STATE OF NORTH CAROLINA
DEPARTMENT OF TRANSPORTATION

December 16, 2011

Subject: **Permit Modification Request for the Individual Section 404 Permit, Individual Water Quality Certification, and CAMA Permit** for the widening of US 158/NC 34 from East of Pasquotank River to the US 158/ NC 34 split in Camden County. Federal Aid Project No. STP-158(2), Division 1, TIP Nos. R-2414 A&B. Debit \$670 from WBS 34430.1.1.

Please see the enclosed revised permit drawings (Sheets 1, 14, 15, 16, 17, 29, 30, 31, 32 of 38), roadway drawings, and revised EEP Acceptance Letter for the above referenced project. Due to the continual rejections of bids by contractors due to the stabilization methods, the NCDOT has redesigned the soil stabilization method which has resulted in impact changes at the three culvert locations on the above referenced project. Due to these changes, a permit modification is requested by the Department.

SITE 6

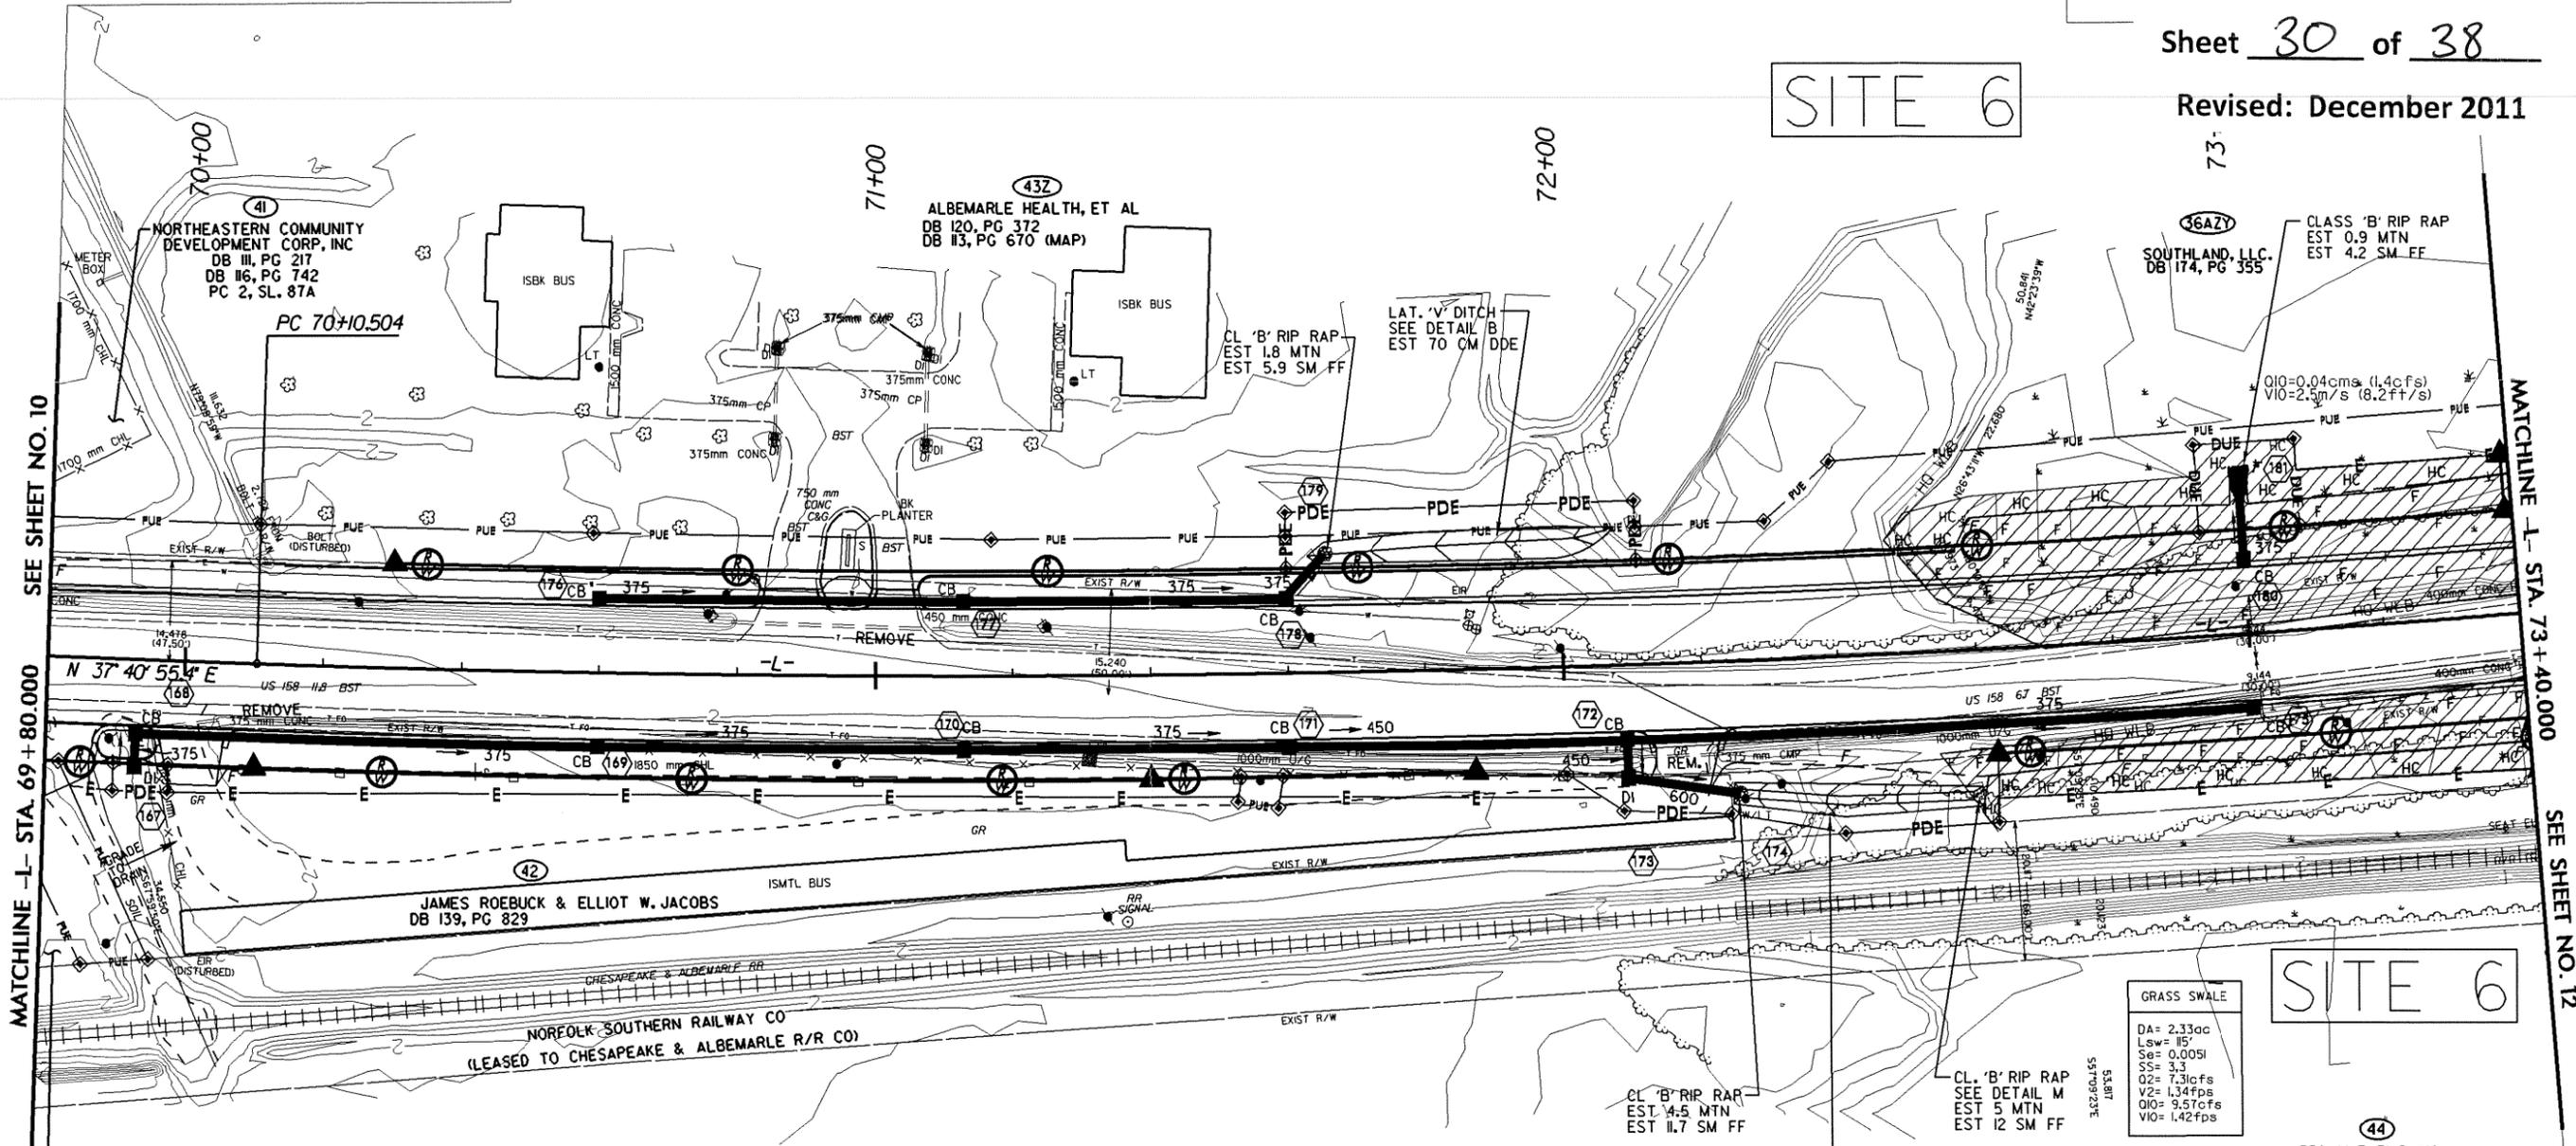
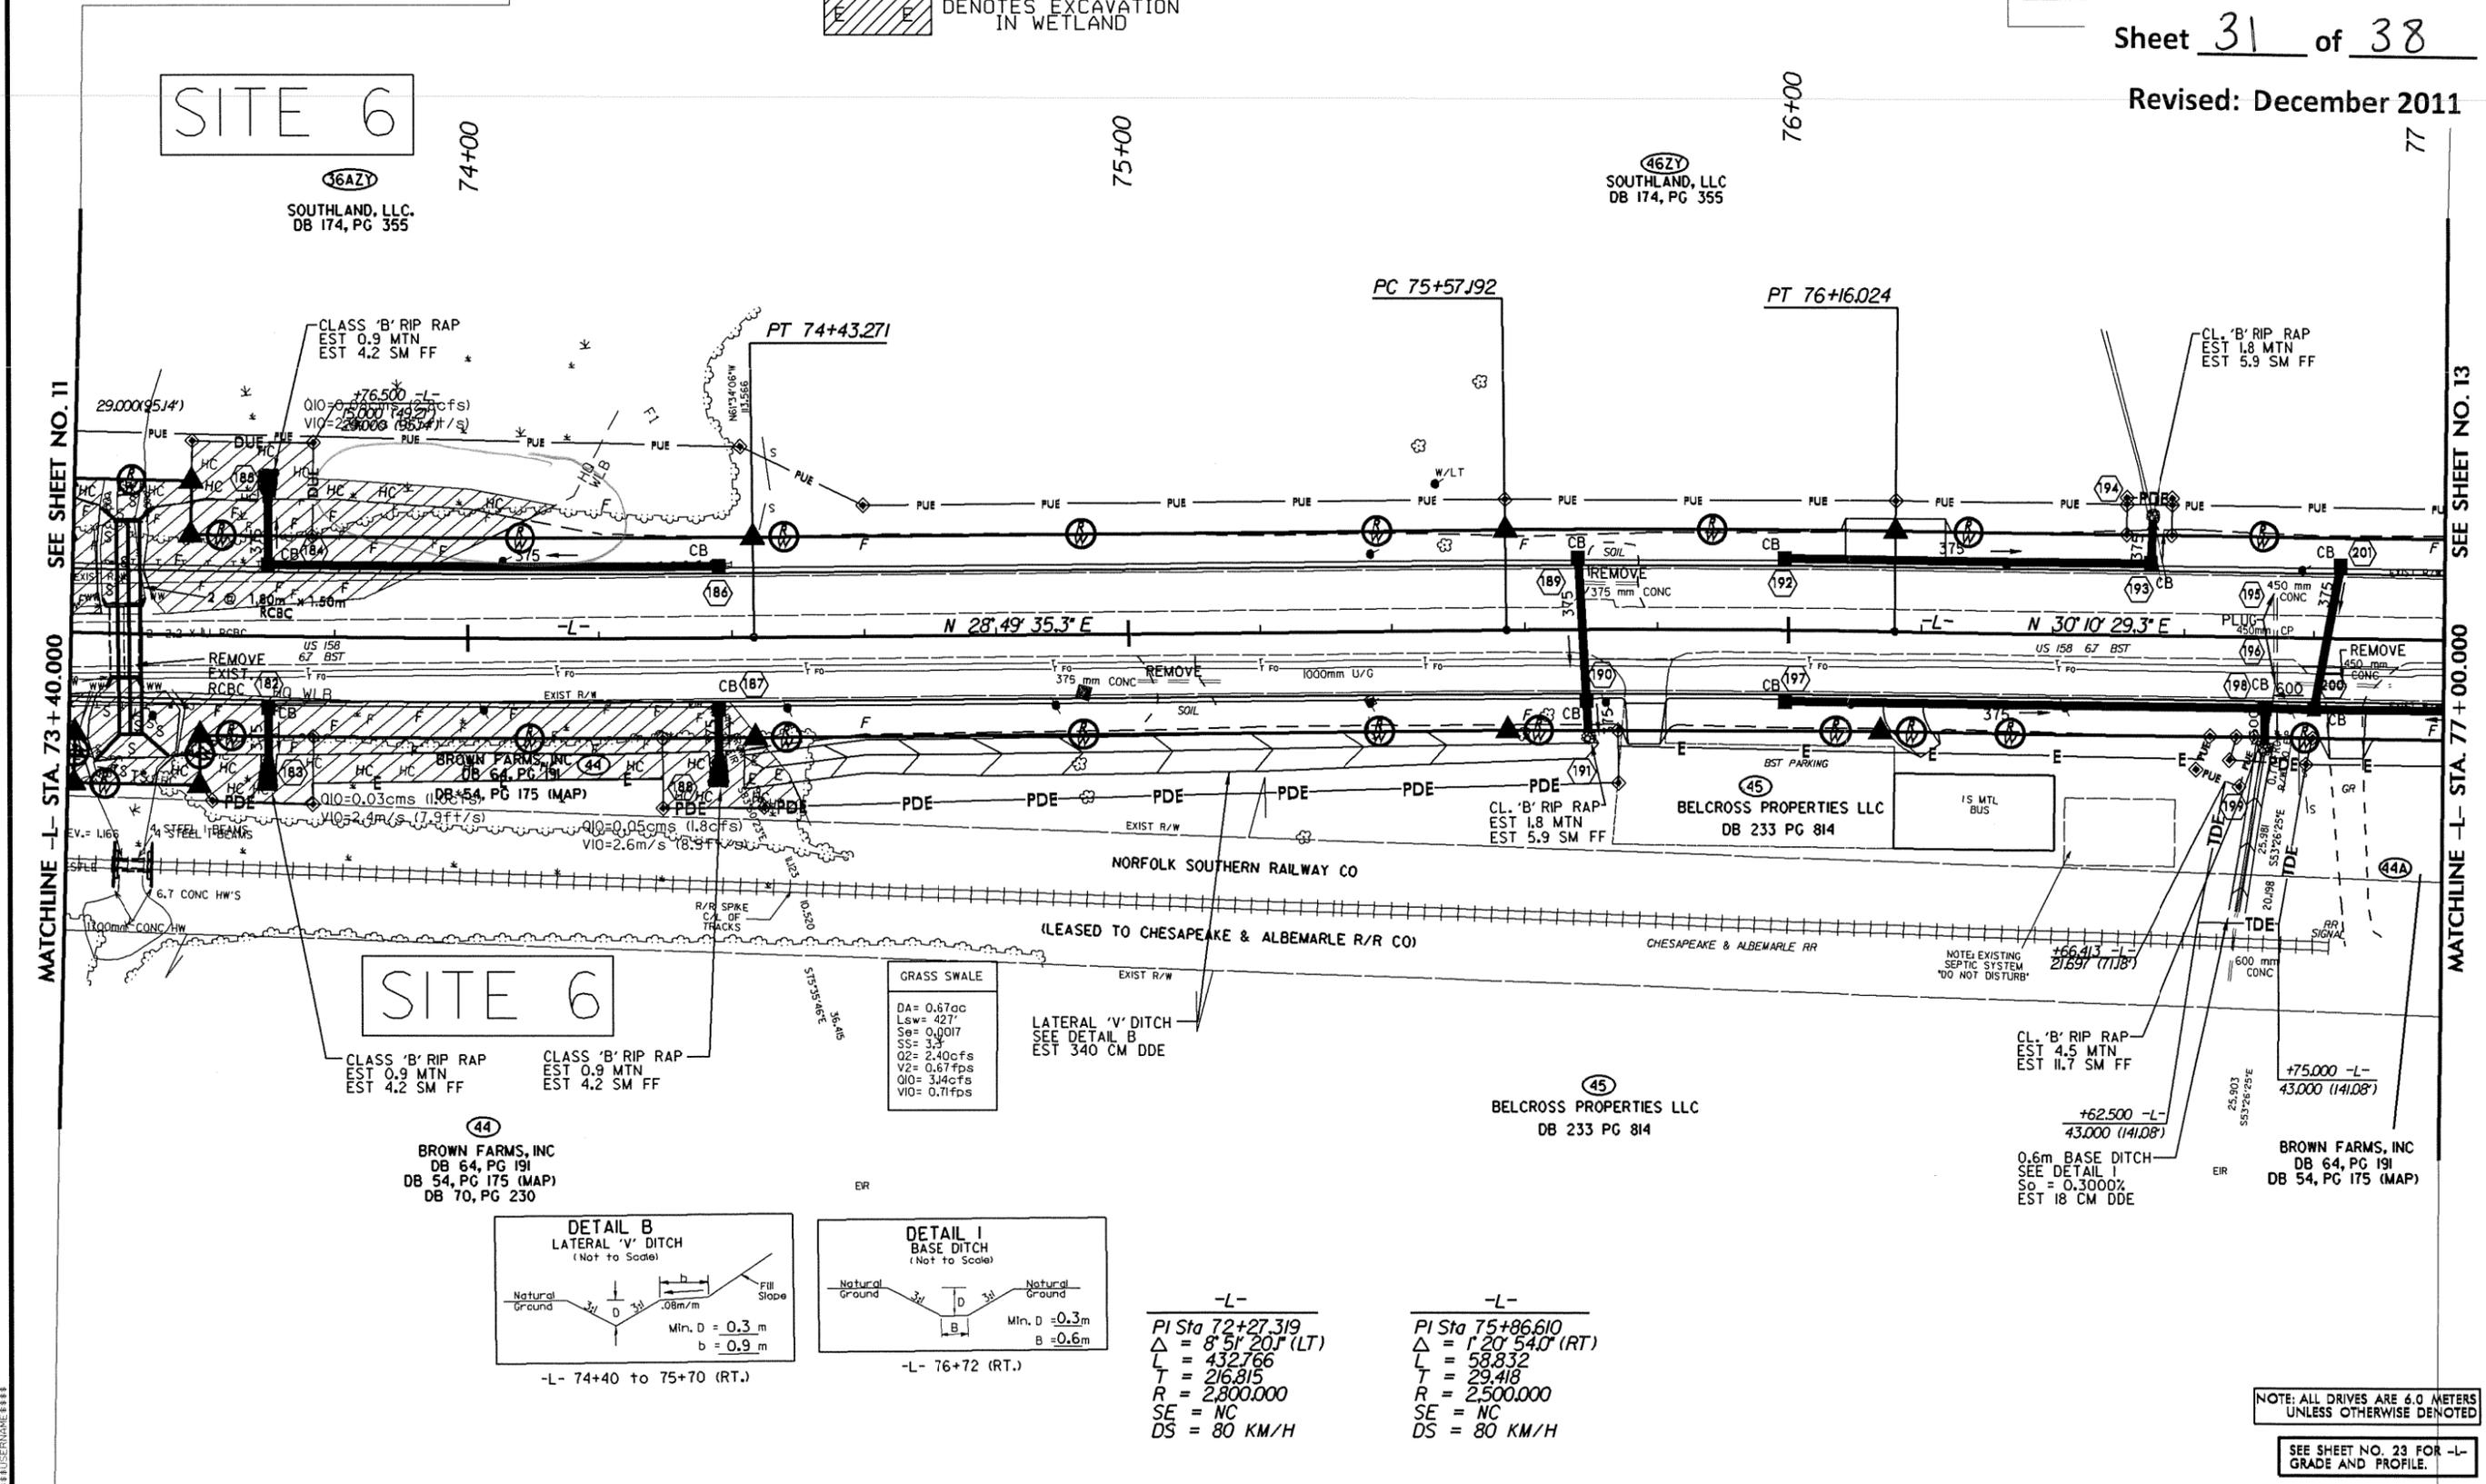
Site 6

The fill slopes will be expanded into an area previously permitted as hand clearing, and the area of hand clearing will also expand out in the amount previously identified in earlier permits (0.37 acre). As a result, the permanent fill in wetlands will increase from 0.85 to 0.87 acre. The hand clearing amount will remain the same (0.37 acre), as it will be moved out from the expanded fill line.

The culvert type has also been reverted back to a double barrel 6’ by 5’ RCBC, as this stabilization method obviates the need for the lightweight aluminum.
